**RESPONSE TO REQUEST FOR ADDITIONAL INFORMATION
SSD-11429726 – EDEN STREET COMMUNITIES PLUS**

This letter has been prepared by Ethos Urban on behalf of Arncliffe Eden Property Pty Ltd in response to the Request for Additional Information (RFI) issued by the Department of Planning and Environment (DPE) for SSD-11429726 dated 17 March 2022. SSD-11429726 seeks approval for the development of land at 26-42 Eden Street and 161-179 Princes Highway, Arncliffe (the site) into a mixed-use precinct with retail and residential uses, involving both market and social housing.

20-171-F01-V1

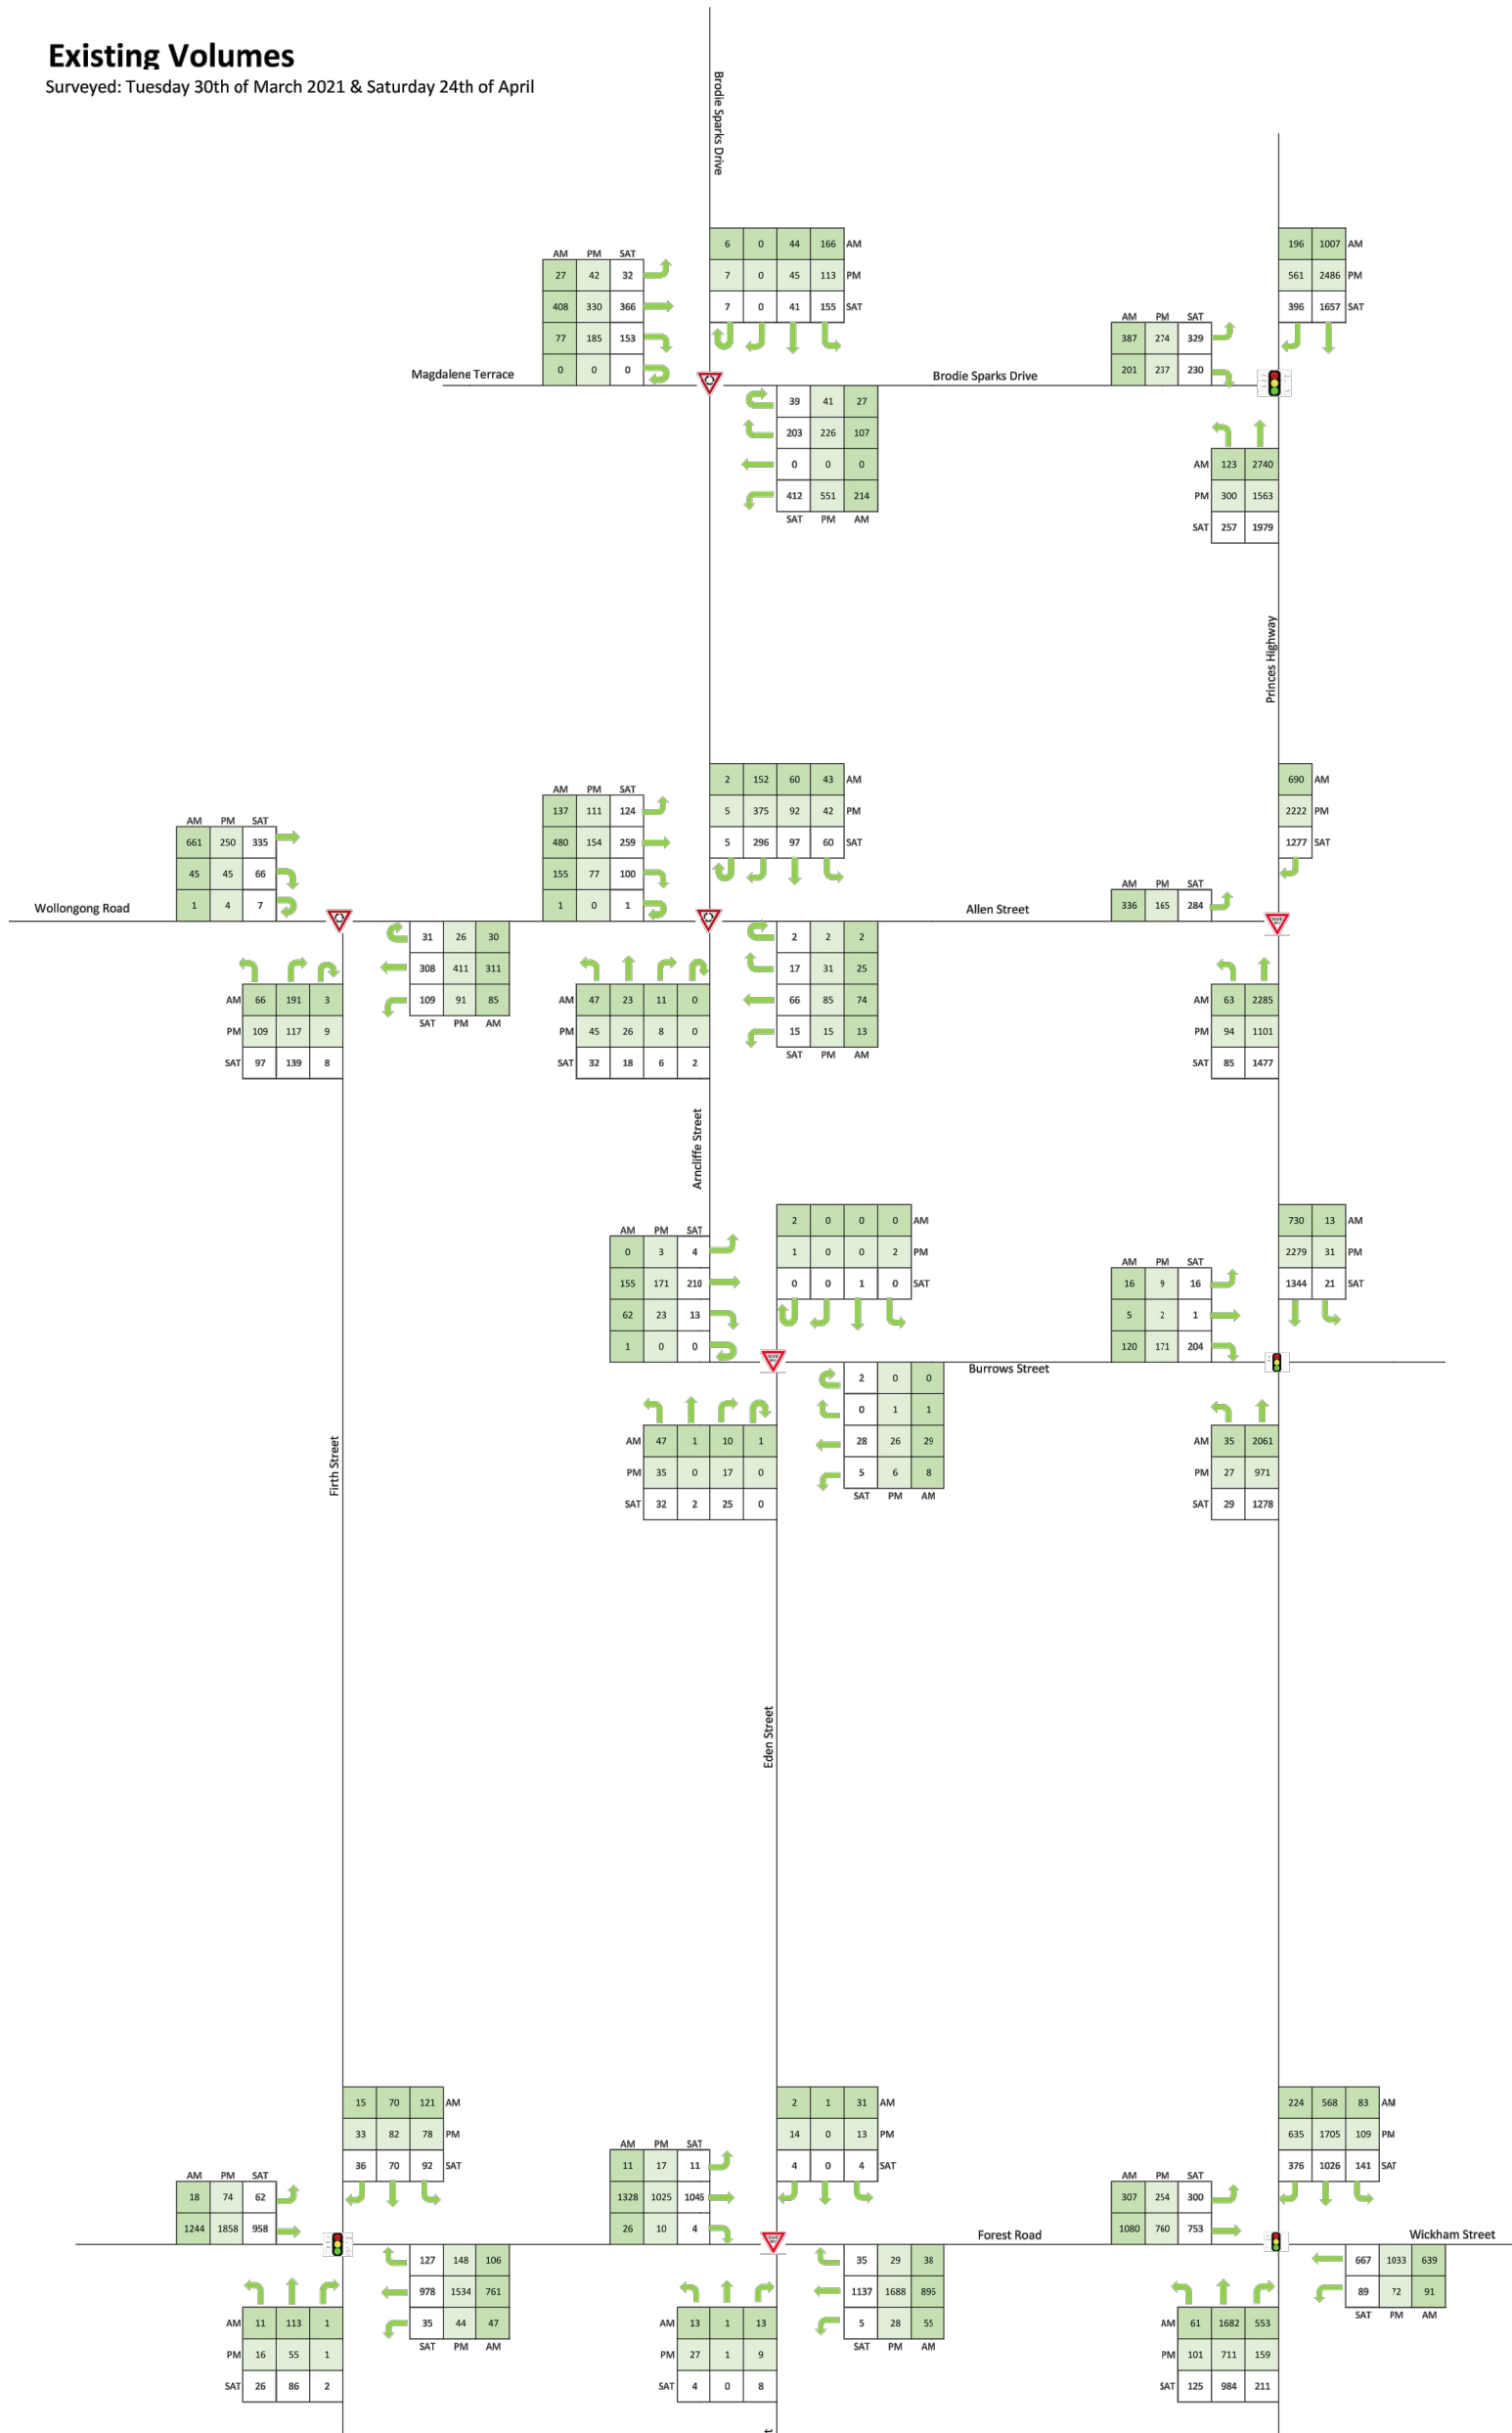
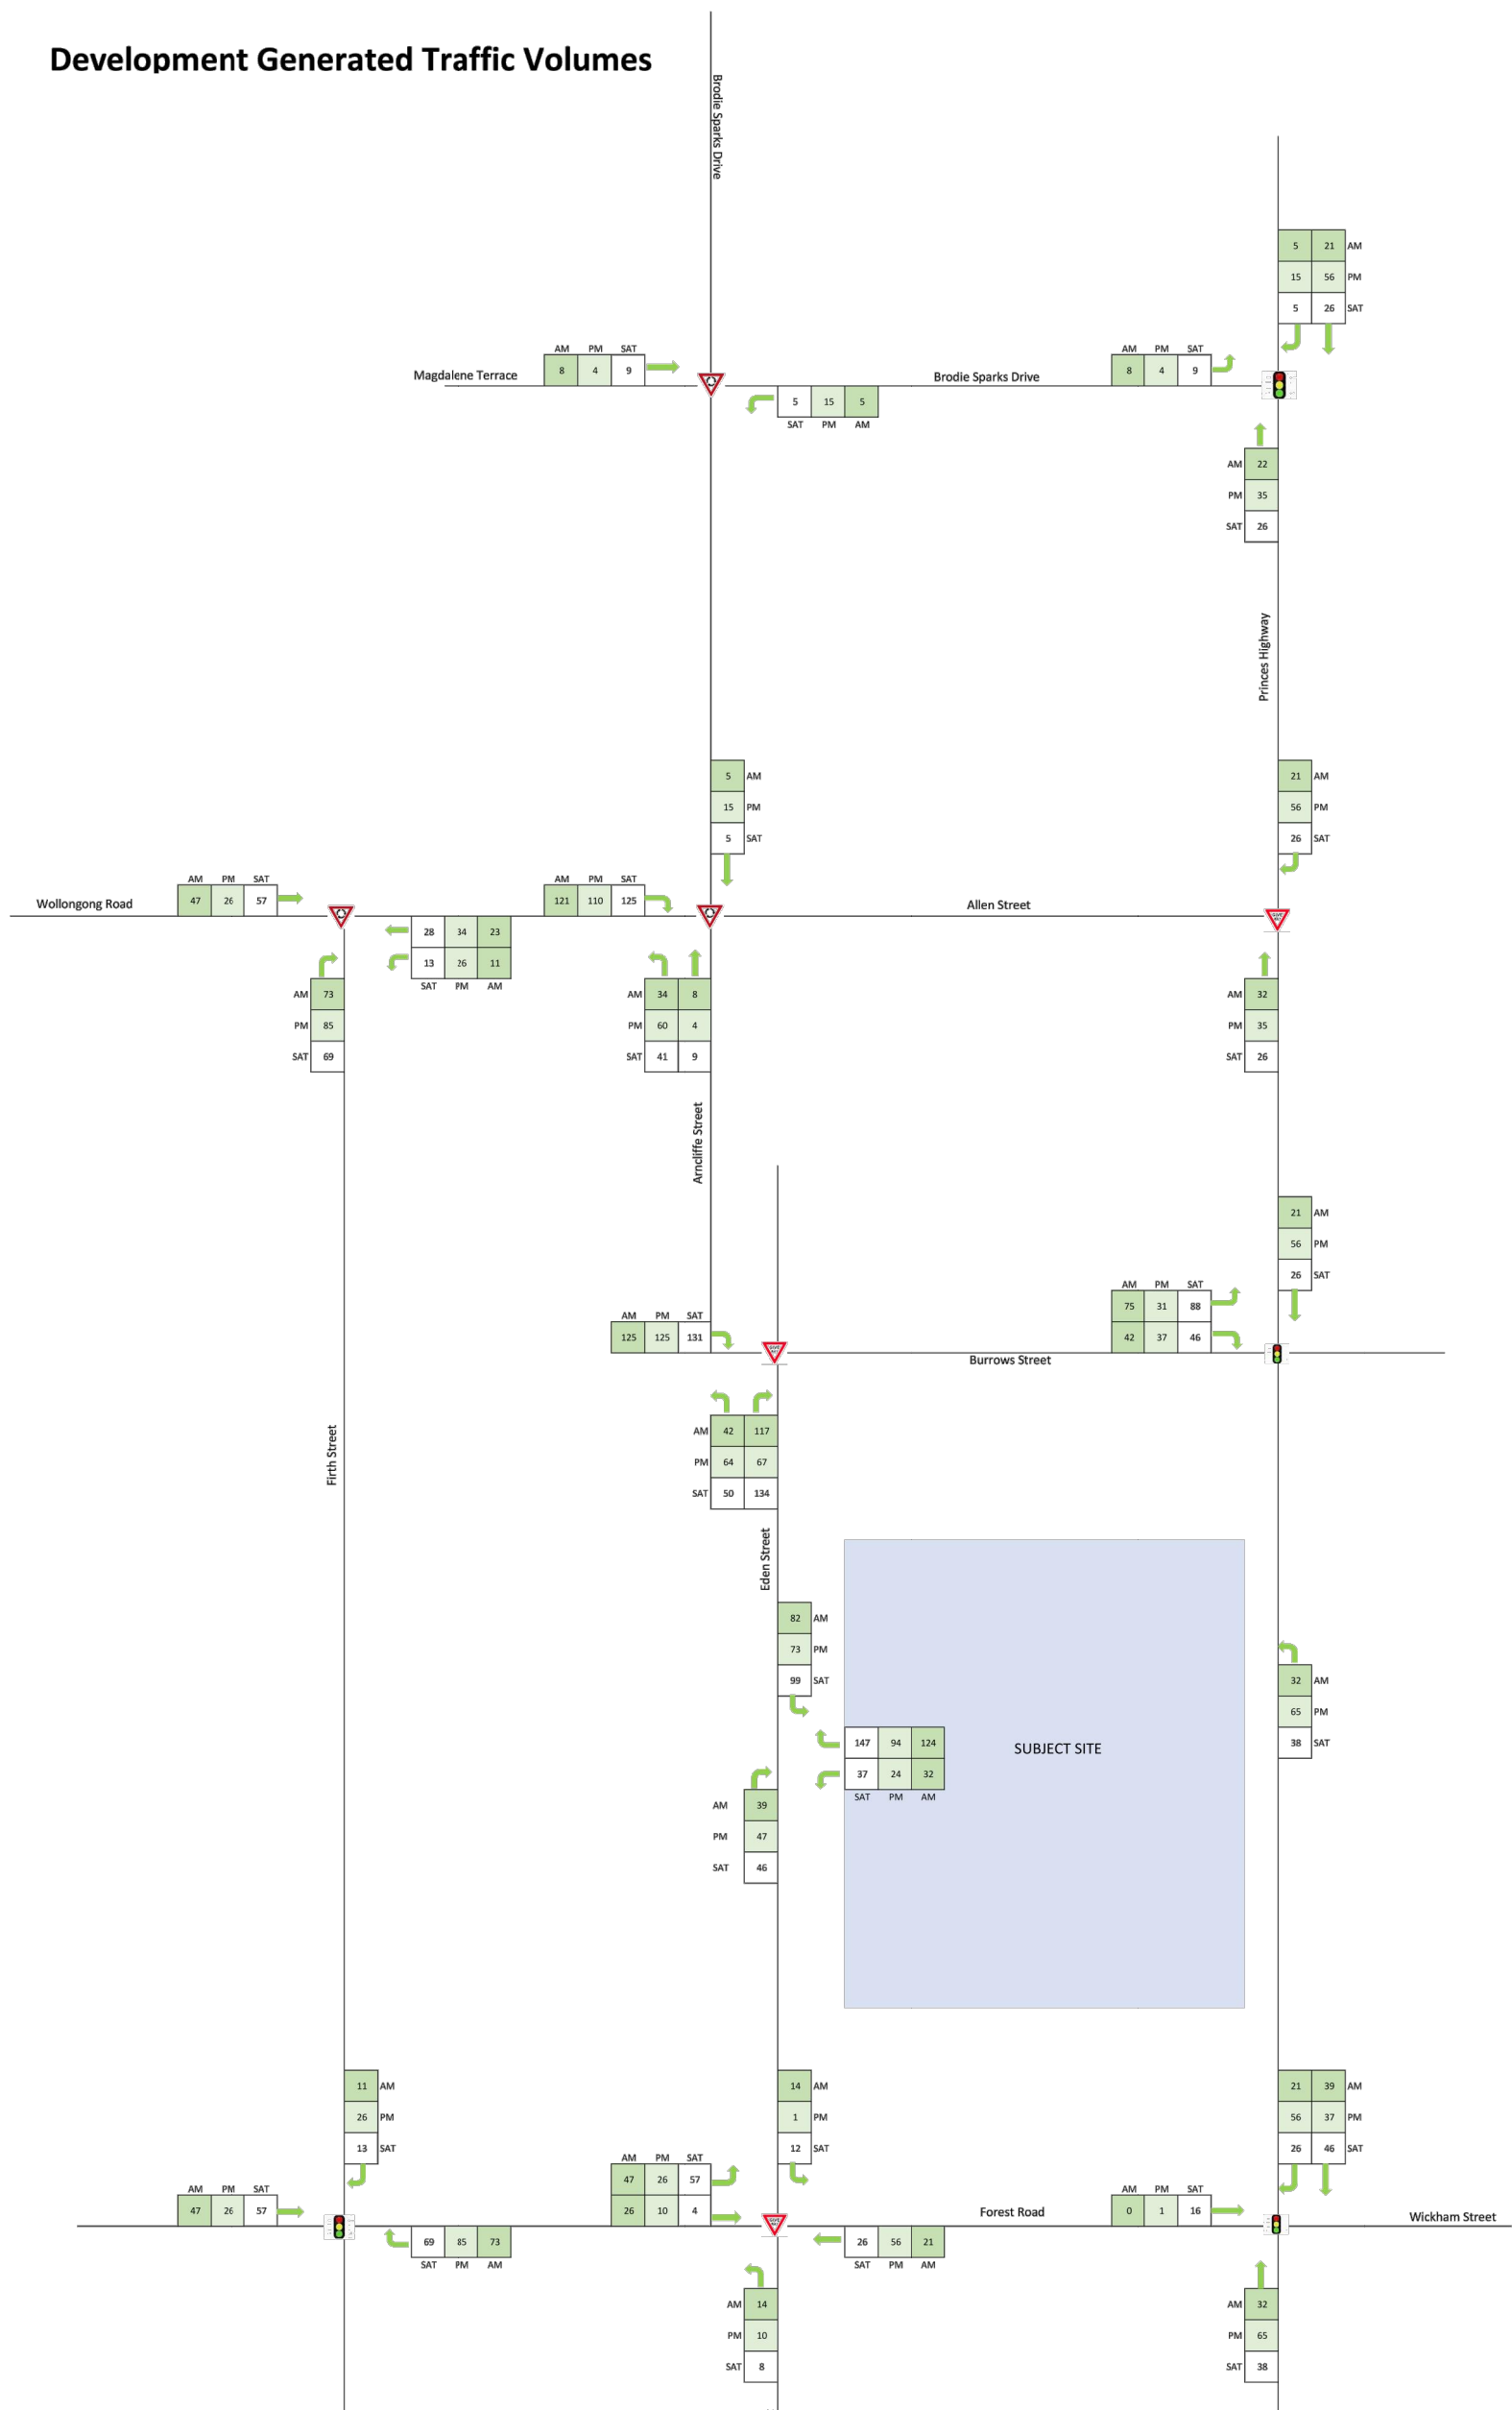
Transport		
15	Provide a summary clearly showing: <ul style="list-style-type: none"> existing and proposed trips and impacts to intersection performance (LOS) during peak periods a diagrammatic representation of predicted travel routes to and from the site. 	Refer to Intersection Performance and Travel Route diagrams prepared by Stanbury Traffic Consulting at Attachment D .
16	Provide details of the studies/analysis undertaken to discount the possibility of including a basement easement to the site to the south.	<p>Potential Basement Easement Connection Statements have been prepared by TTW, Stanbury Traffic Consulting and Corporate Counsel Services at Appendices E, F and G, confirming that a potential future basement connection to the lots south of the site would be unfeasible from structural integrity, traffic planning, and legal perspectives.</p> <p>Accordingly, the proposal would be unable to accommodate this easement.</p>
